OXFORDSHIRE COUNTY COUNCIL'S RESPONSE TO CONSULTATION ON THE FOLLOWING DEVELOPMENT PROPOSAL

Application no: 15/02103/REM

Proposal: Reserved Matters to application 06/00967/OUT - Provision of Local Centre to include Community Centre (Class D1), Youth Centre (Class D1), Nursery (Class D1), Convenience Store (Class A1), 4 x retail units (Class A1/A2/A3/A4 and/or A5) and associated development including public square, landscaping, car parking, recycling point and ancillary servicing yard off Whitelands Way, at the Kingsmere development, South West Bicester

Transport

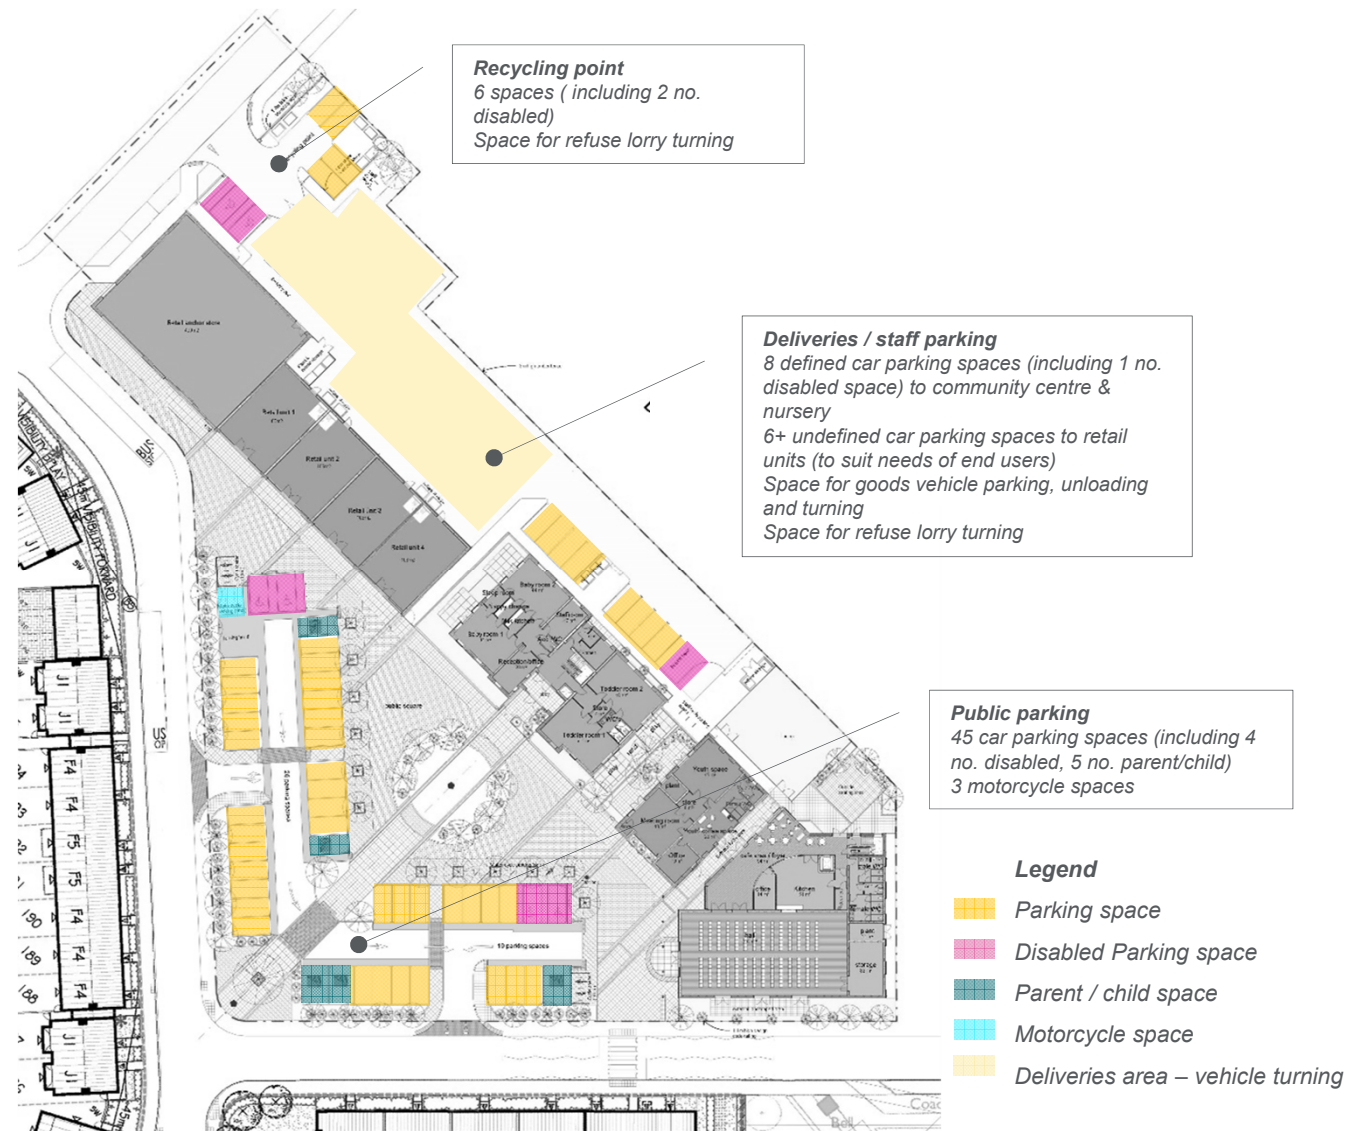
Car parking spaces should measure 5 x 2.5m which was agreed upon at the pre app stage. Some of the spaces provided appear slightly narrower and for a development likely to generate a high turnover for parking spaces, it is imperative to have wider parking bays with 6m space between rows.

The location of visitor cycle parking stands is acceptable where they are prominently placed within public realm. However, only 20 spaces are provided which for an area such as this, set within a sustainable location and is anticipated to serve a larger part of the 1,585 dwellings as part of the larger consented development, the number of visitor cycle spaces must be increased.

11 SOUTH WEST BRISTOL (UNIMARKS) UNIMARKS (UNIMARKS) 2779-ATR-002.DWG 16/11/2015 15:35:50 Rev. 01

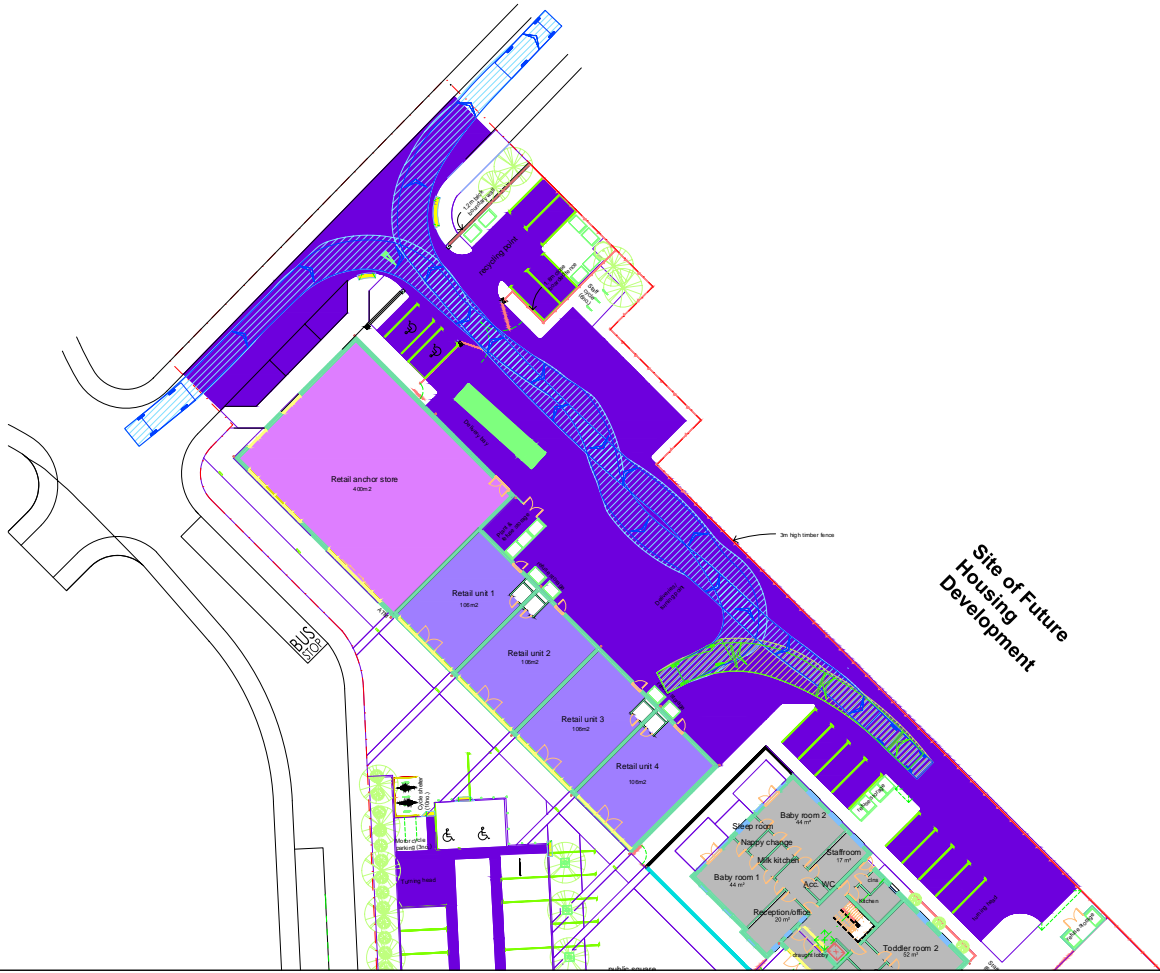
Since the occupant of the Retail anchor store (convenience store) is unknown at this stage, tracking for maximum size articulated trucks is recommended to show that possible future deliveries made by all types of trucks to the store shall be accommodated within the curtilage of the site.

The lack of a turning head at the eastern end of the car park (nearest to the community hall) makes it impossible to assess the manoeuvrability of vehicles in and out of parking spaces. Vehicle tracking for the extreme end spaces should be provided to demonstrate the possible manoeuvre of vehicles into/out of these spaces (the disabled space and the one closest the cycle shelter).
